Jeanie Bourke - RE: Get Air Portland

FLOOR PLAN
SCALE 1/4" = 1'-0"

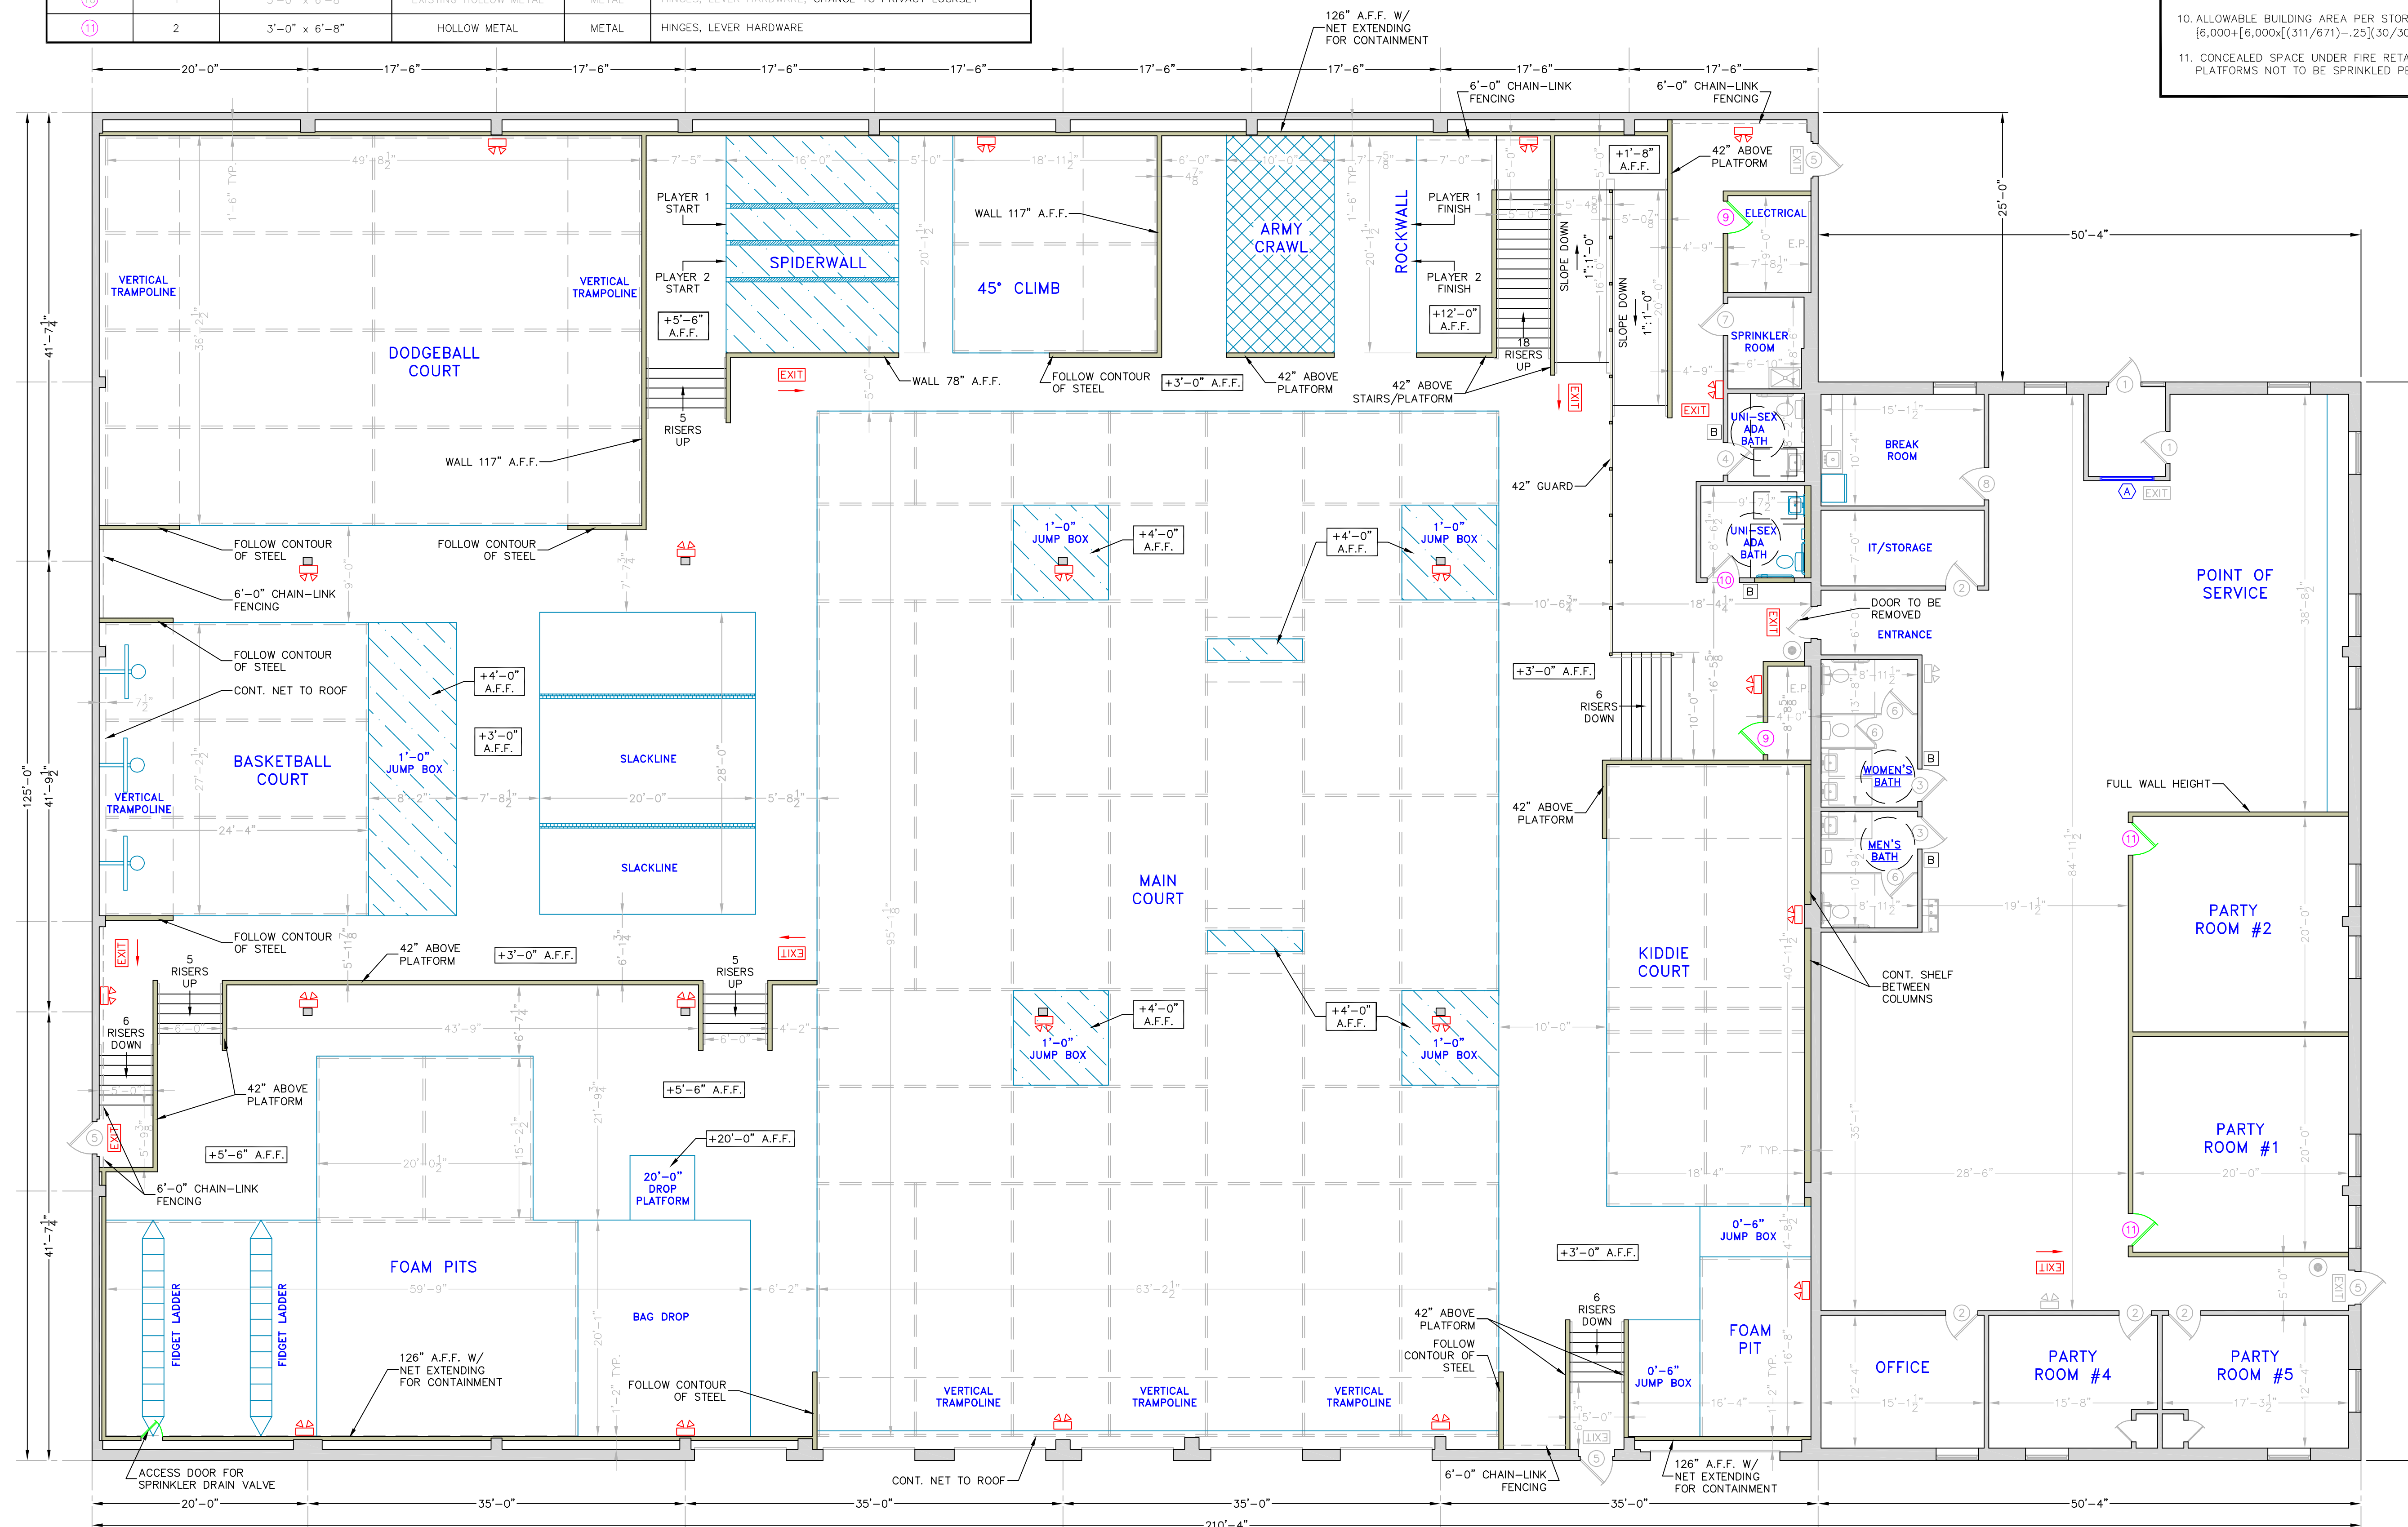
Thank you for this clarification. We would like the trampoline fixture drawings once available, I will include this as a condition of permit approval.

Brian forwarded over your comments on the floor plan concerning the part of the plan that is labeled 20'-0" Drop Platform in reference to the framing for this piece. The Drop Platform will be a fixture made by the trampoline company similar to the fixtures for the trampolines themselves. Therefore, we did not provide framing for it on our S-1 framing plan. Once approved, the trampoline company will be designing all of the fixtures for the facility. If you wanted some additional information on this or any other fixture as far as its construction, they could provide design drawings at that time similar to a truss drawing submittal. Let me know if you have any questions. Thanks.

DETAILS

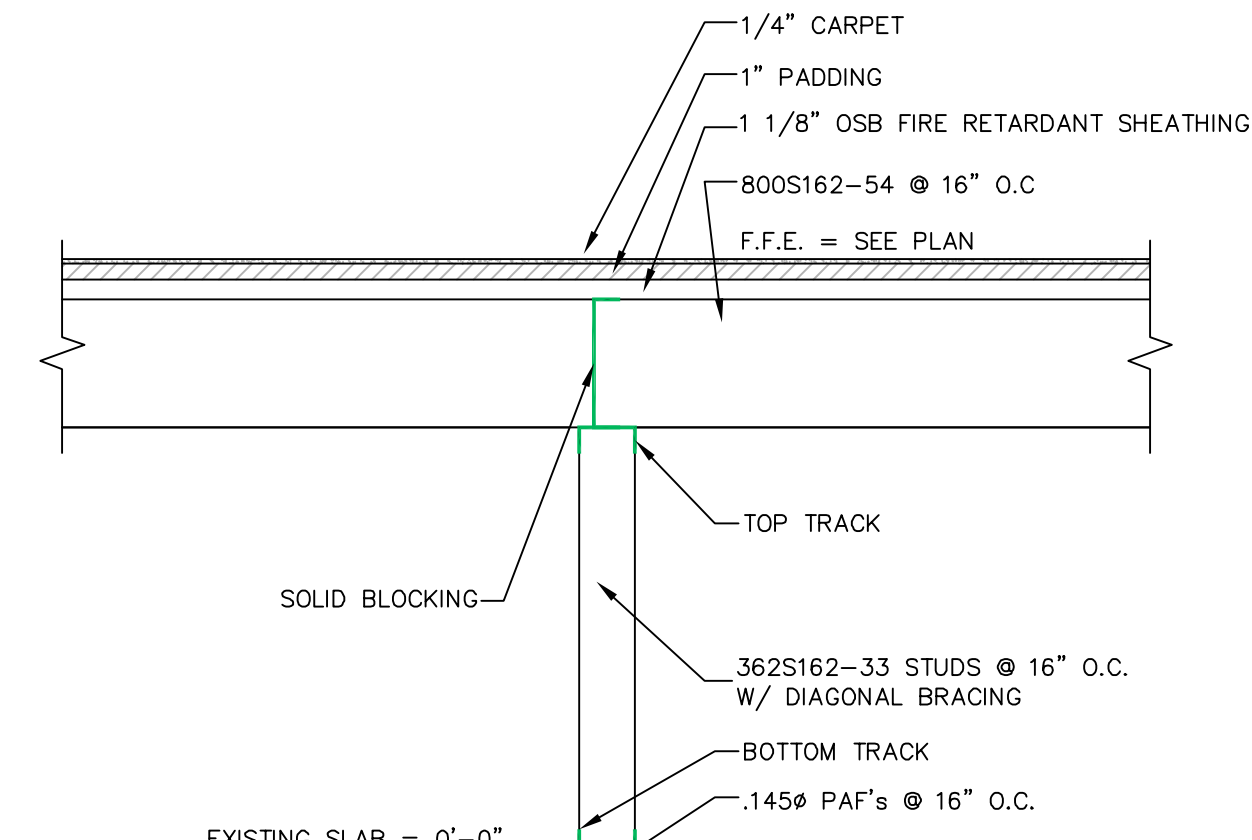
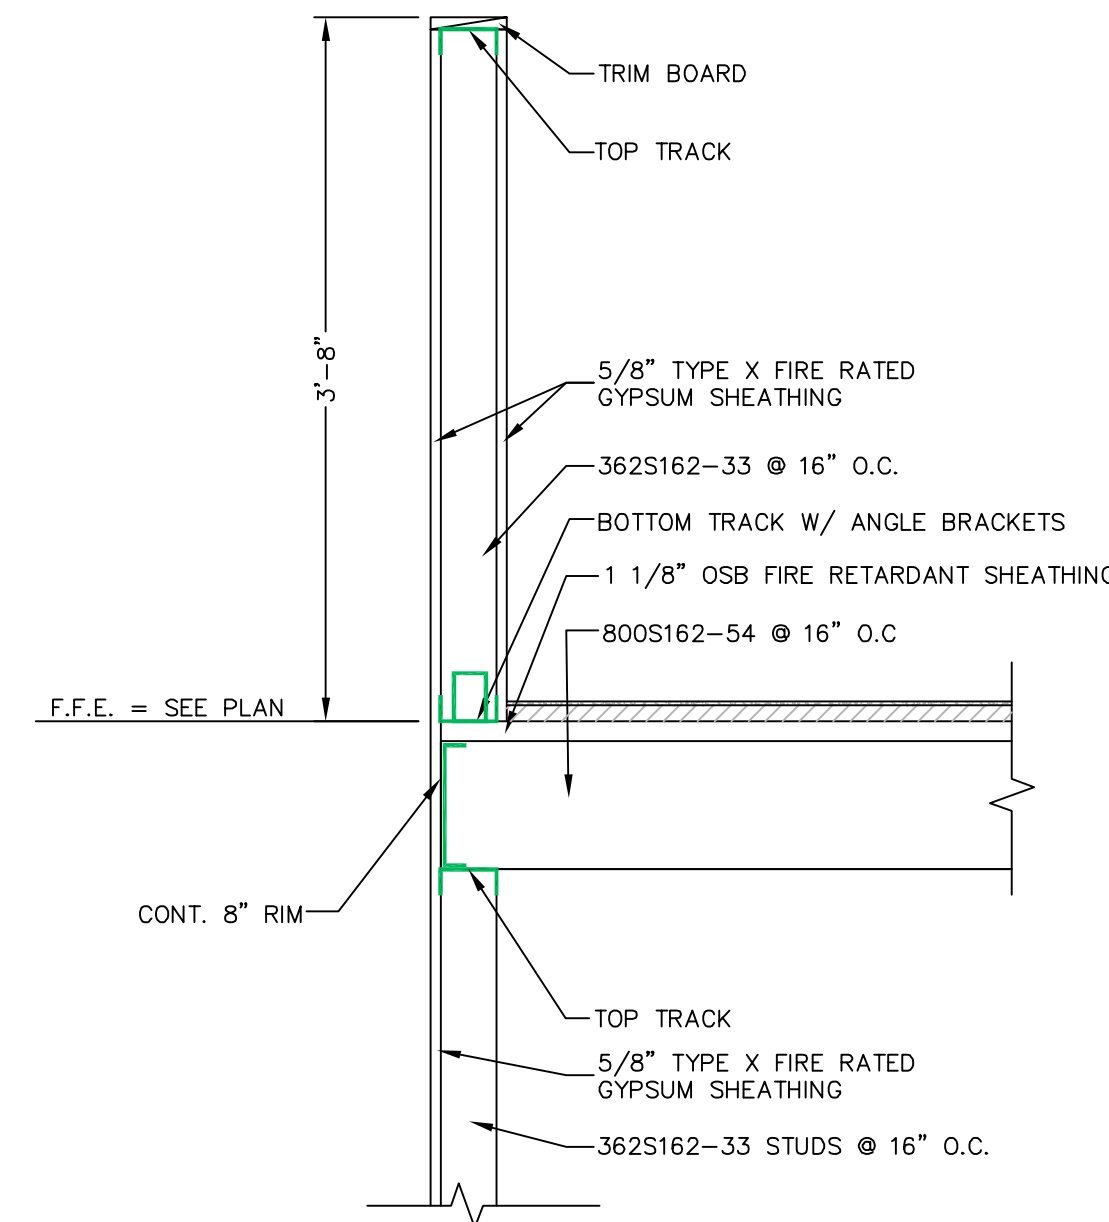
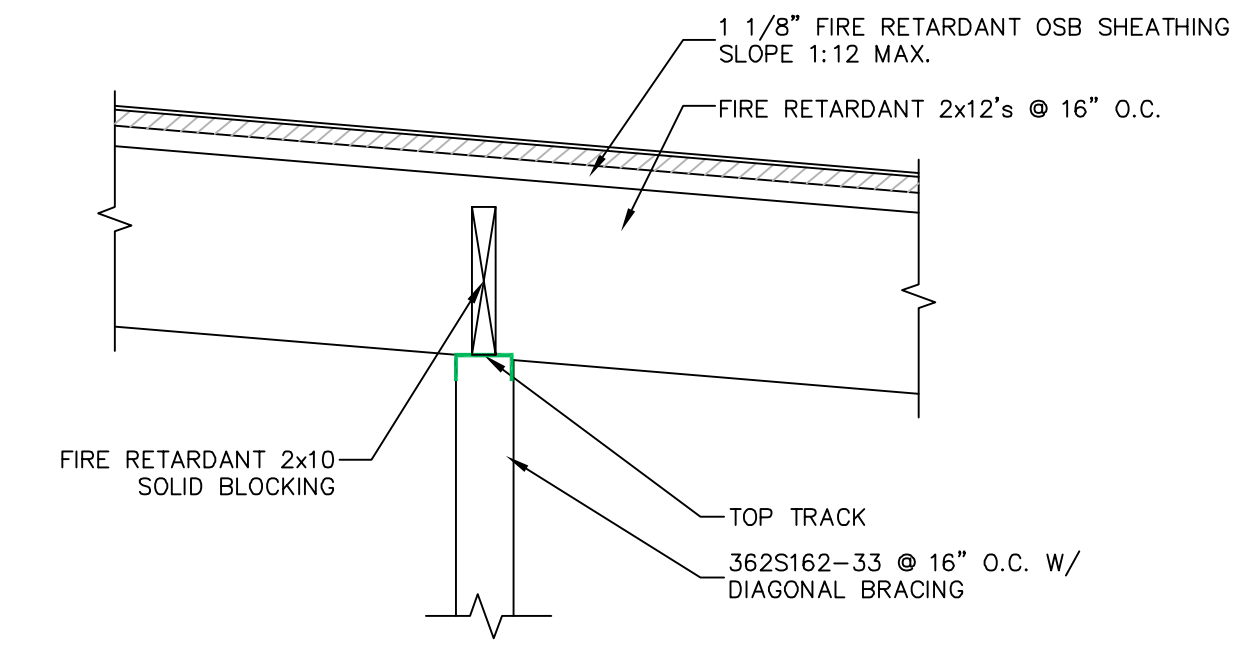
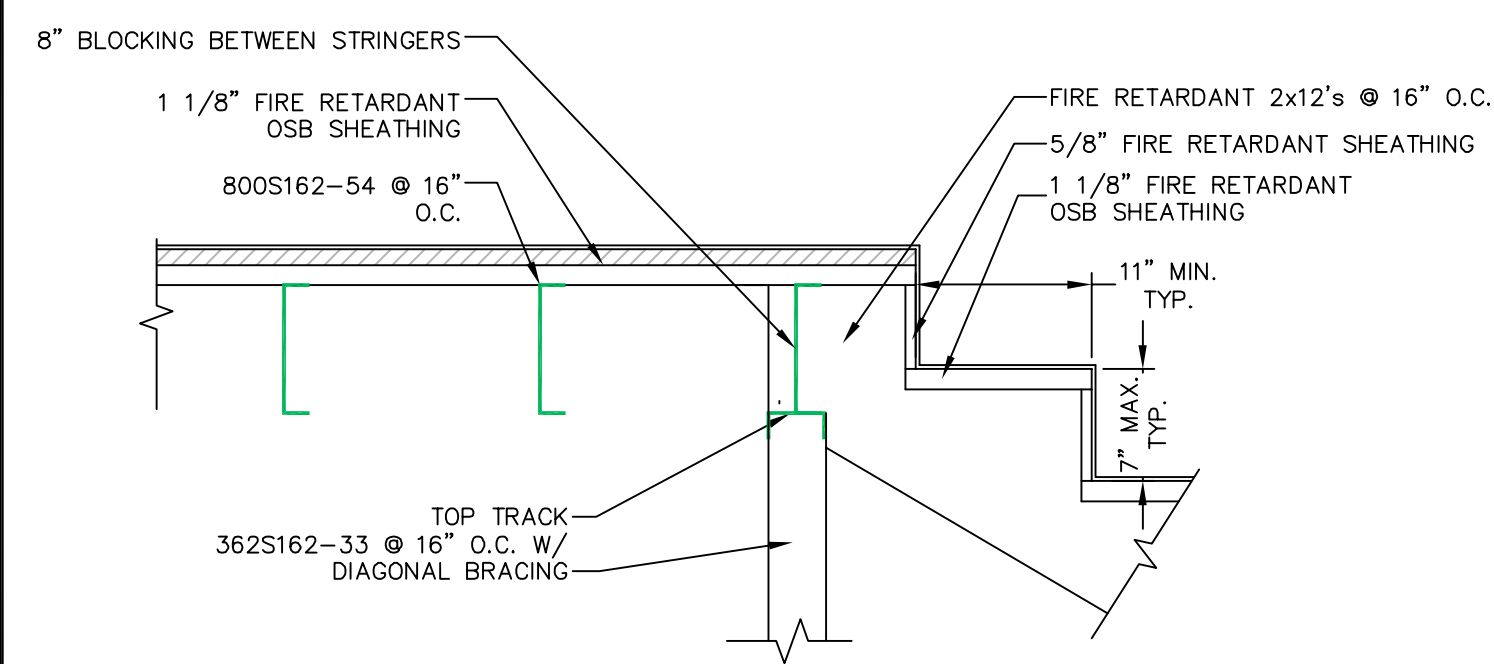
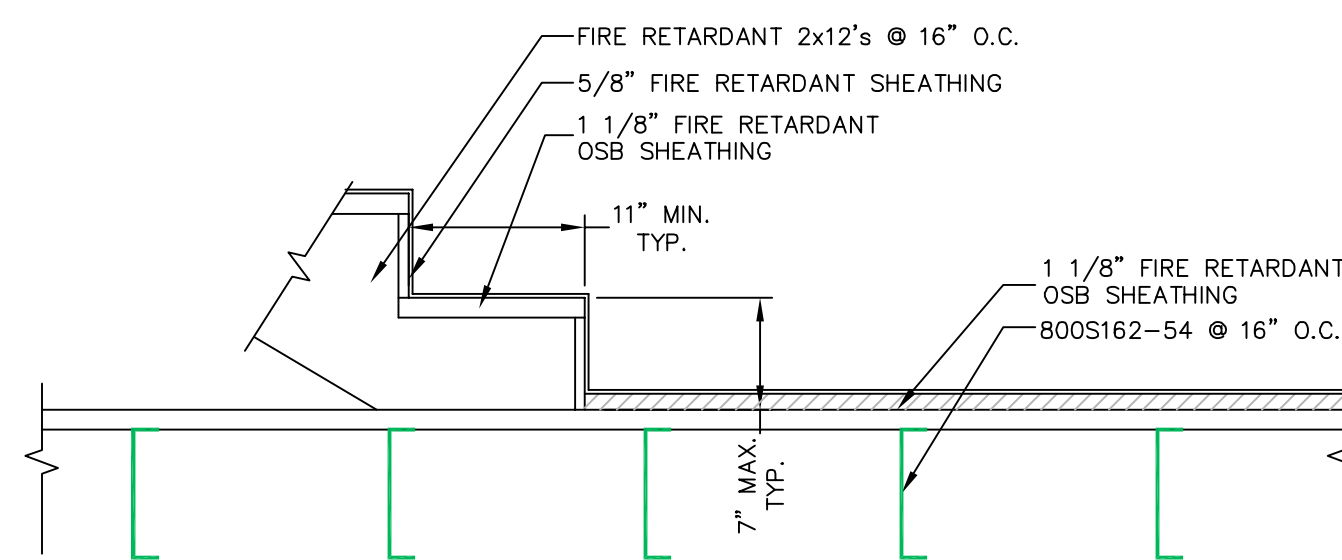
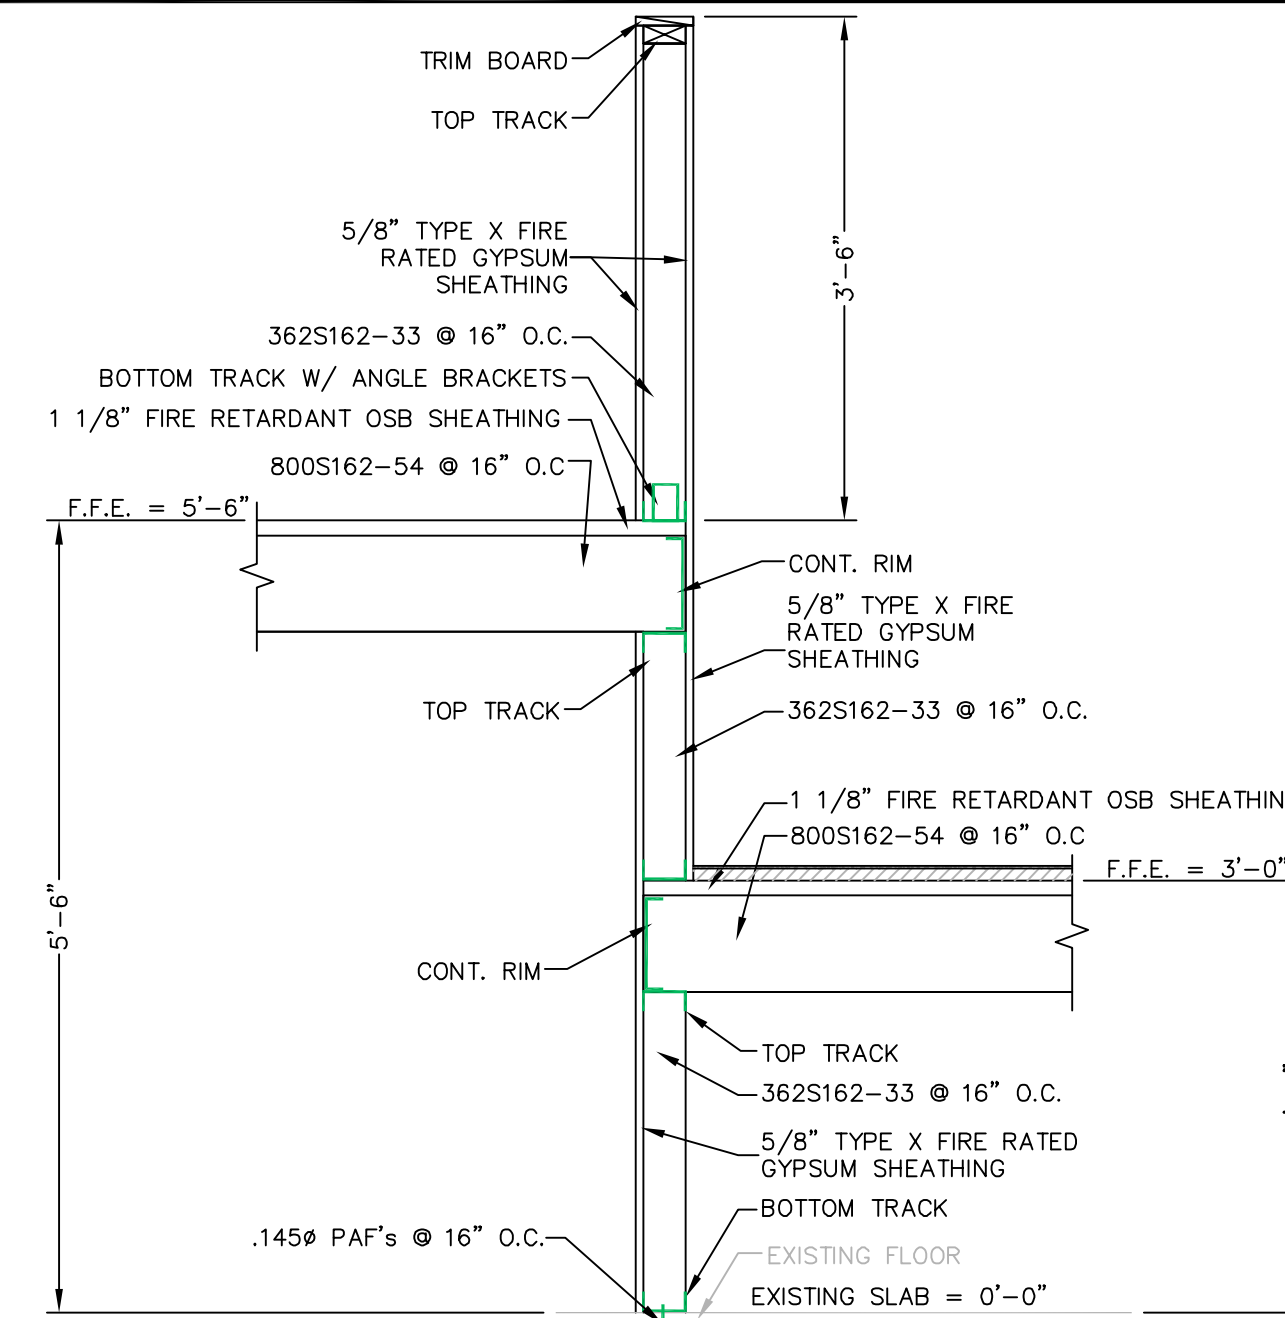
1. As this was previously a warehouse, how is this new use complying with the IECC, Energy Code? There are new walls being built at most of the perimeter exterior walls, but the detail does not include insulation. Please confirm if this was a conditioned space or if this is newly conditioned.
2. Will there be an HVAC system installed, was there one previously? If so, these plans should be submitted.
3. Will there be any commercial kitchen, either full or partial? If not, what are the plans for food? catering?

1. There are some new walls being constructed on the interior side of the exterior wall to act as boundaries for the fixtures. They are not full height and only go to the top of the fixtures. The rest of the walls are receiving a simple netting or chain link to protect the existing wall. The existing space is currently heated.
2. There are no proposed HVAC systems being installed. We propose using all of the existing systems with no additions.
3. There is to be no commercial or partial kitchens in the fit-up. The food to be used in the Party Rooms will be brought in, most likely pizzas.
